7 February 2022

**FOREST GLEN SOLAR FARM - SSD-9451258**

Property: Lot 6 DP 755102, 30L Delroy Road MINORE

APPENDIX 4:  
INDICATIVE SUBDIVISION PLAN

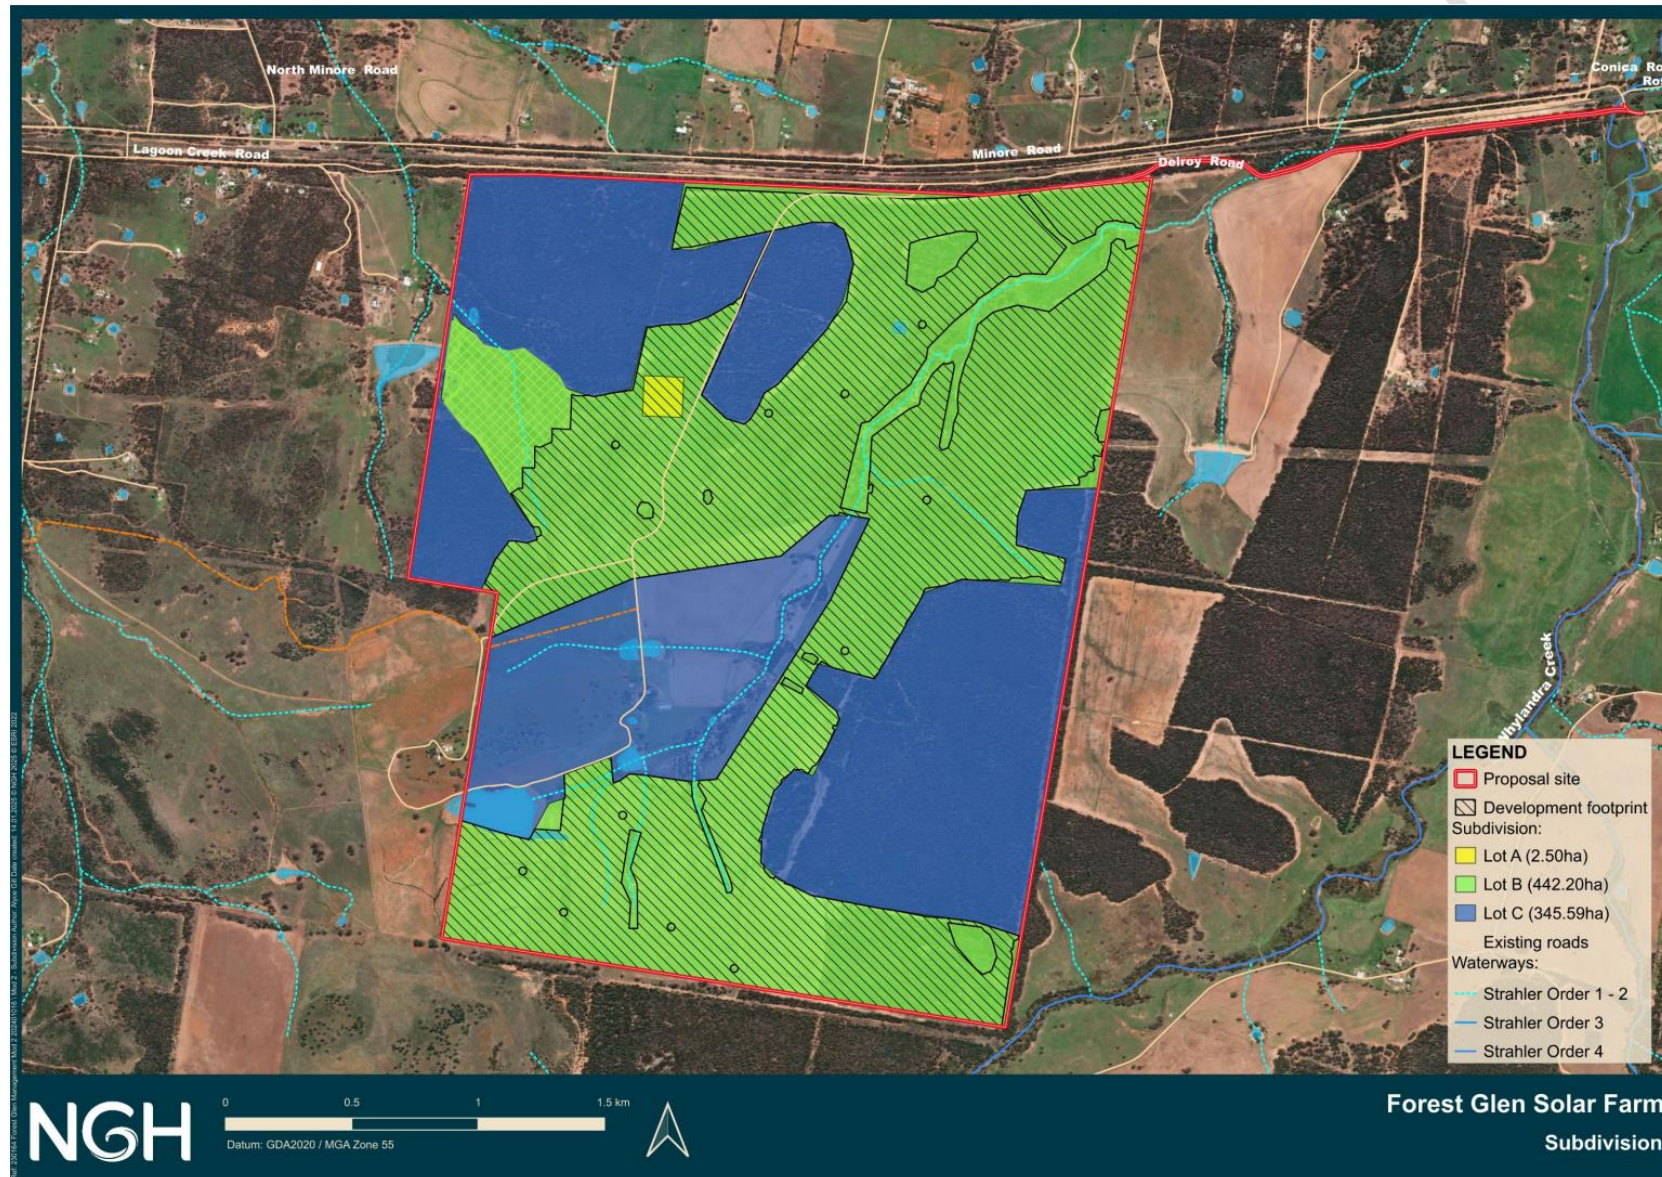
The EIS identifies that the subject property is intended to be subdivided into three (3) allotments – Lot A for Essential Energy's new substation; Lot B being the intended area to be leased by the Proponent; and Lot C being the land to be retained by the existing landowner. With respect to Lot C, it will comprise four (4) separate parcels which are not contiguous with each other. Further, three (3) of the four (4) parcels have no public road access. Consequently, it will be necessary for 'Rights of Carriageway' to be created to provide the landowner with legal access to each of these parcels across Lot B.

Figure 2 Minore Road & Delroy Road intersection

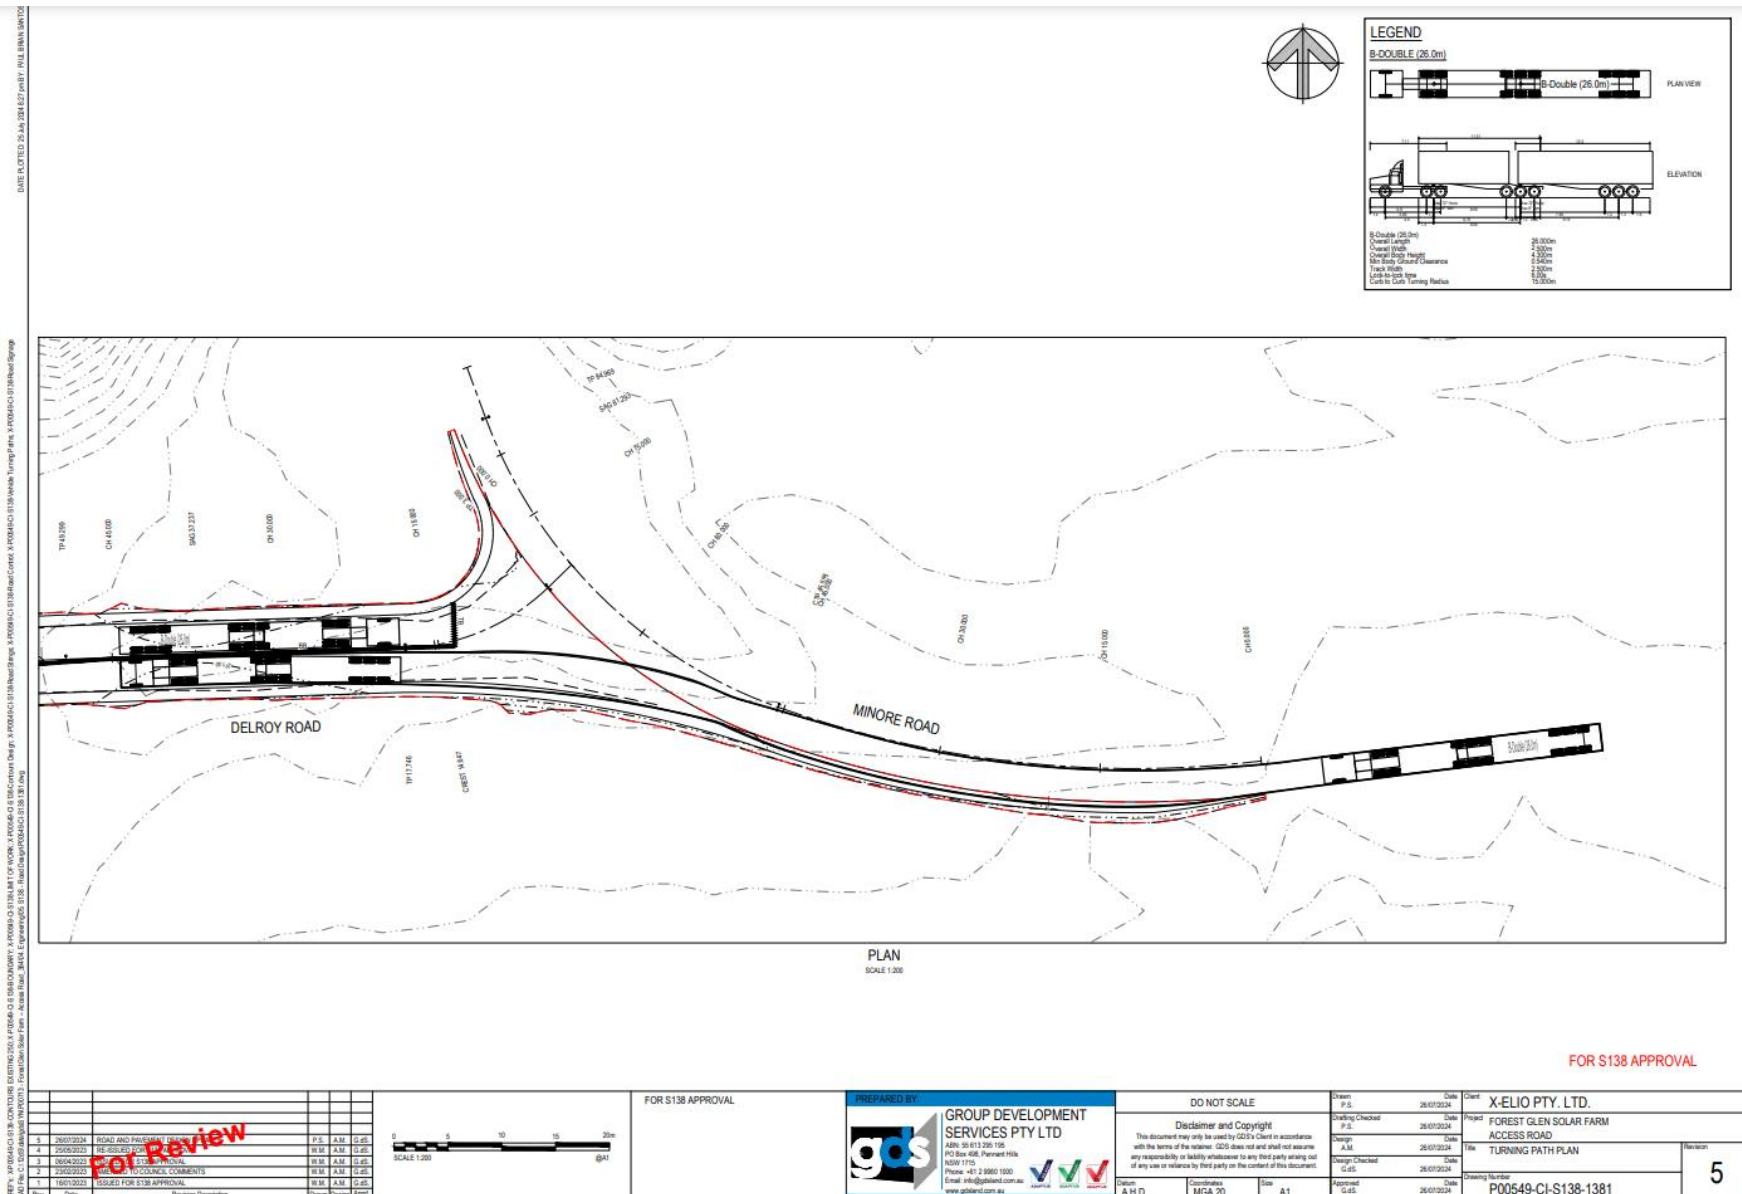
- A dilapidation report to be undertaken on Minore Road prior to construction and repairs be made to the preconstruction condition of Minore Road.
- Delroy Road shall be upgraded from the site access to the intersection of Delroy and Minore Roads (including the bridge underpass) with priority given to Minore Road traffic.

- As part of the construction phase, attention will be required to assist the movement of large vehicles at this intersection.
- From an engineering perspective it is acknowledged that there will be an increase in traffic during construction. The network is considered as being able to accommodate a mix of traffic types and volumes. In this regard Council is considering:
